Ribble Valley Borough Council  
Development Control

Application no: 3/2019/1102  
Address: 4 Longridge Road, Hurst Green  
Proposal: Extension to existing garage to form Annexe

**2** PROPOSED SITE PLAN

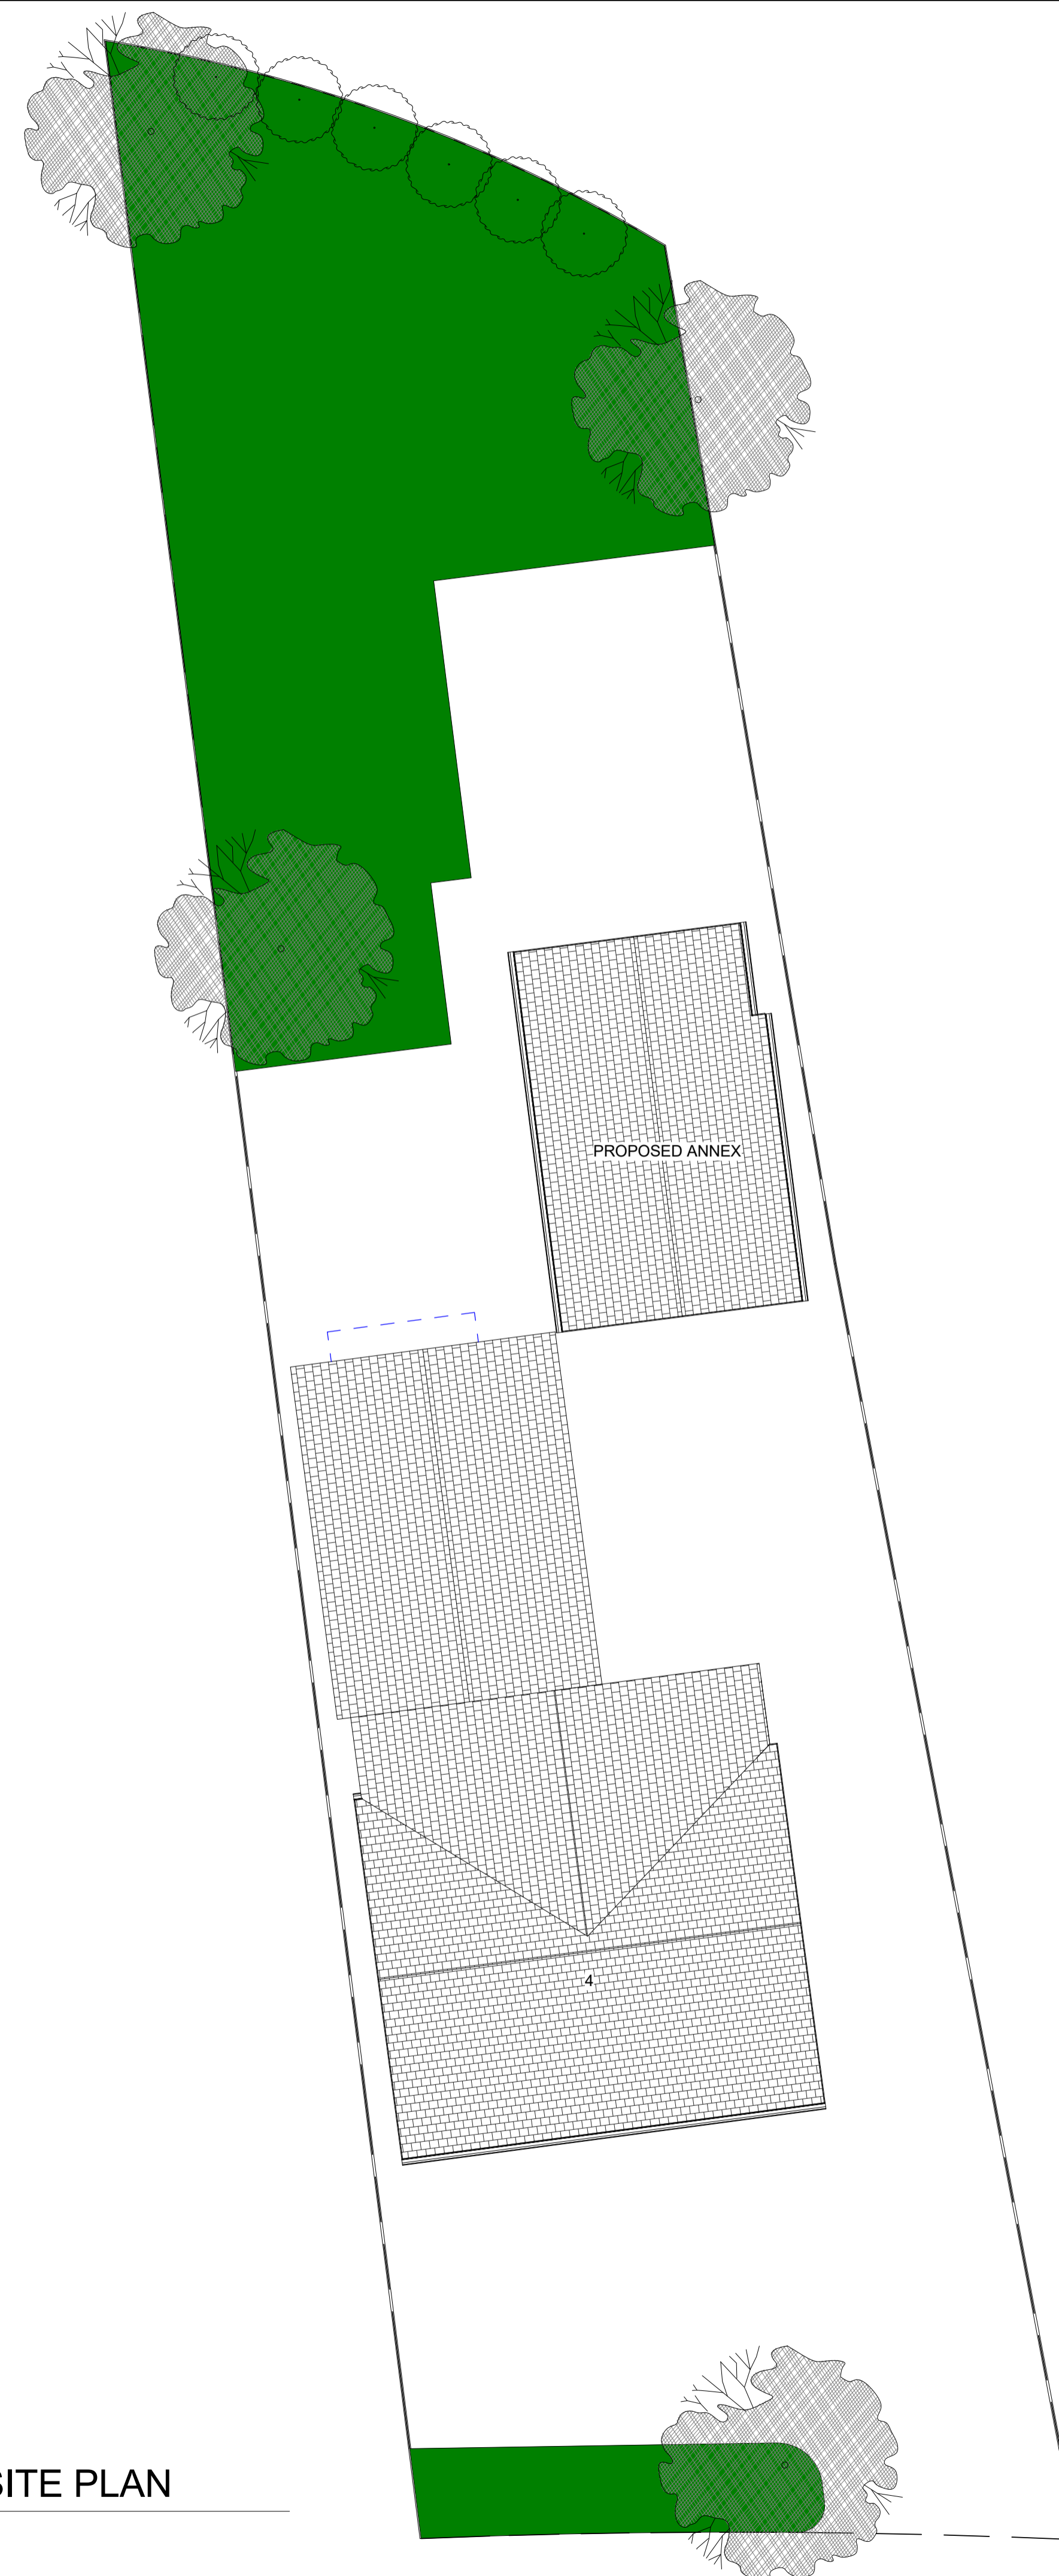
The proposal is unlikely to raise any highway concerns but as the proposed development will result in the addition of an extra bedroom and sufficient facilities for the proposal to be occupied independently of the main dwelling I would need to be satisfied that the parking provision will be adequate. Therefore subject to the provision of an acceptable parking plan I would raise no objection to the proposal on highway grounds.
